**CITY OF ALBUQUERQUE
PLANNING DEPARTMENT
November 13, 2013
DRB Comments**

PROJECT # 1009880

APPLICATION # 13-70743

RE: Lot 6E1C, Montgomery Heights

IMPROVEMENT LOCATION REPORT LOT 6-E1-C, MONTGOMERY HEIGHTS CITY OF ALBUQUERQUE BERNALILLO COUNTY, NEW MEXICO

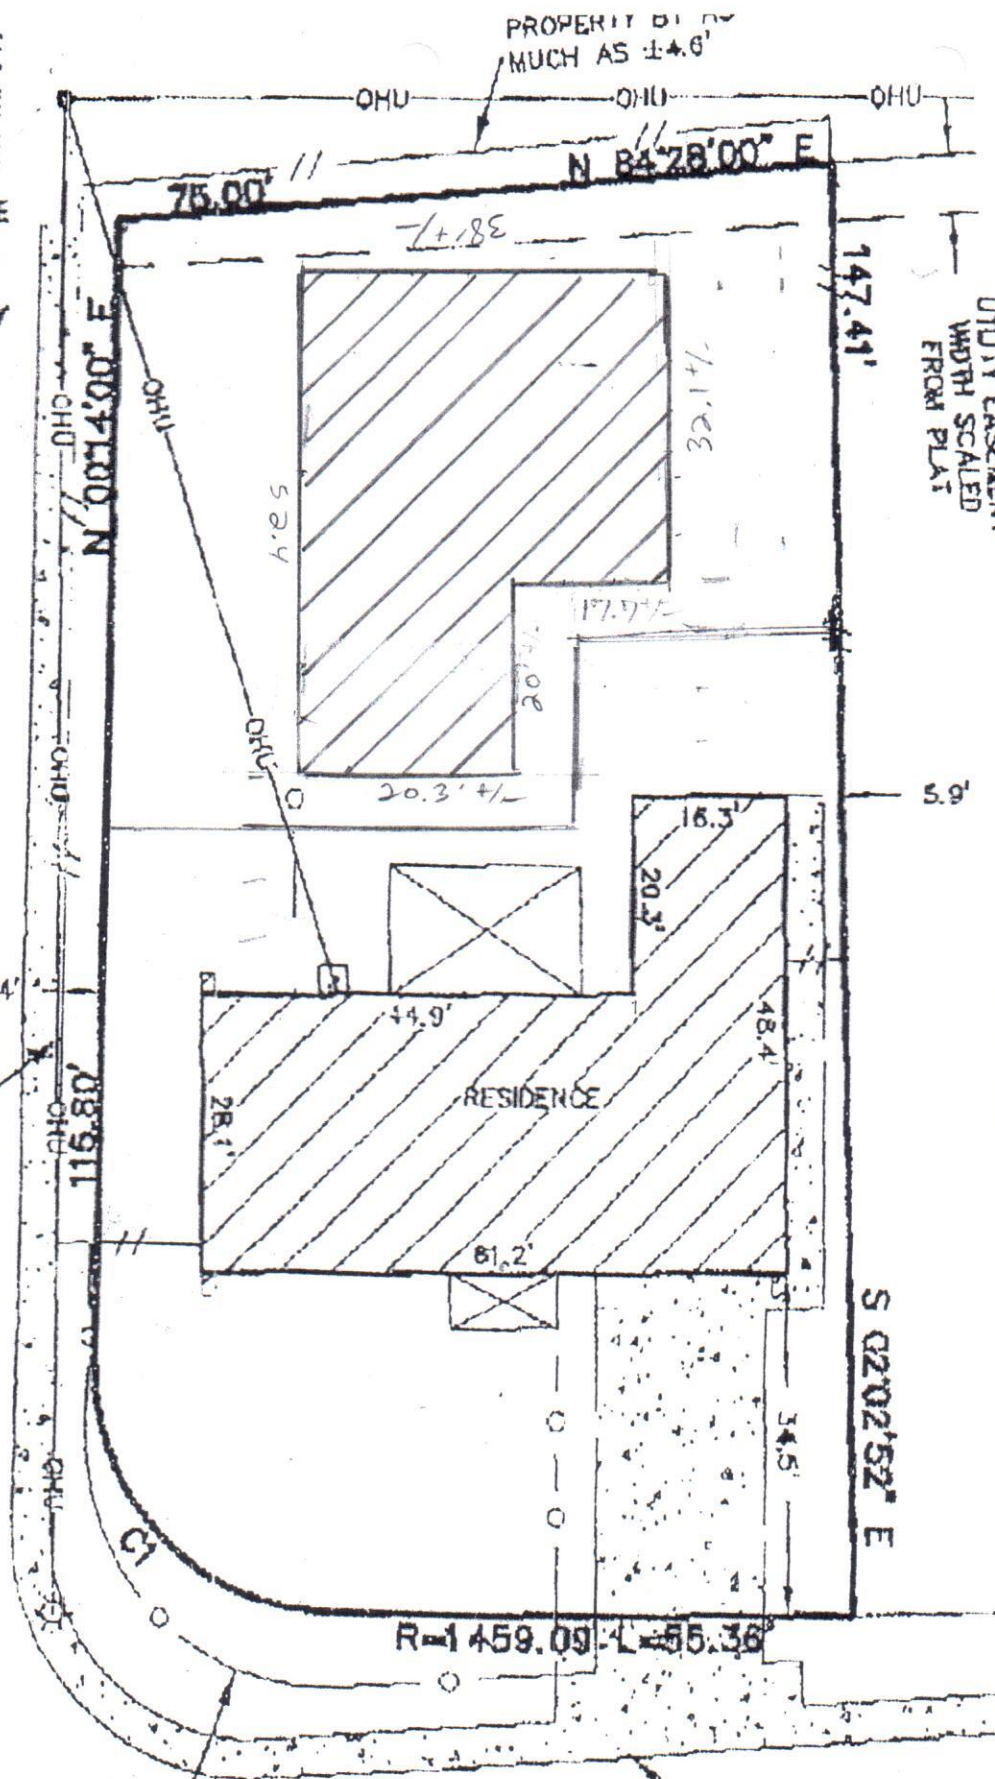
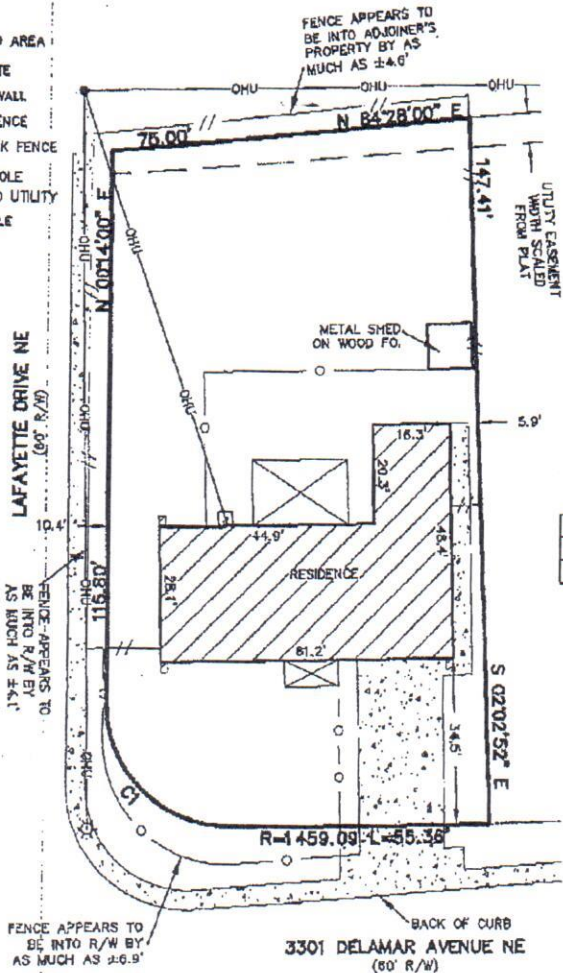
A zone change would be required to create proposed lots; recommend scheduling a Pre-application Review Team/ PRT meeting to discuss feasibility. It appears the minimum change necessary would be to change to R-T zone – verification from Zoning Enforcement would be needed for proposed building setbacks.
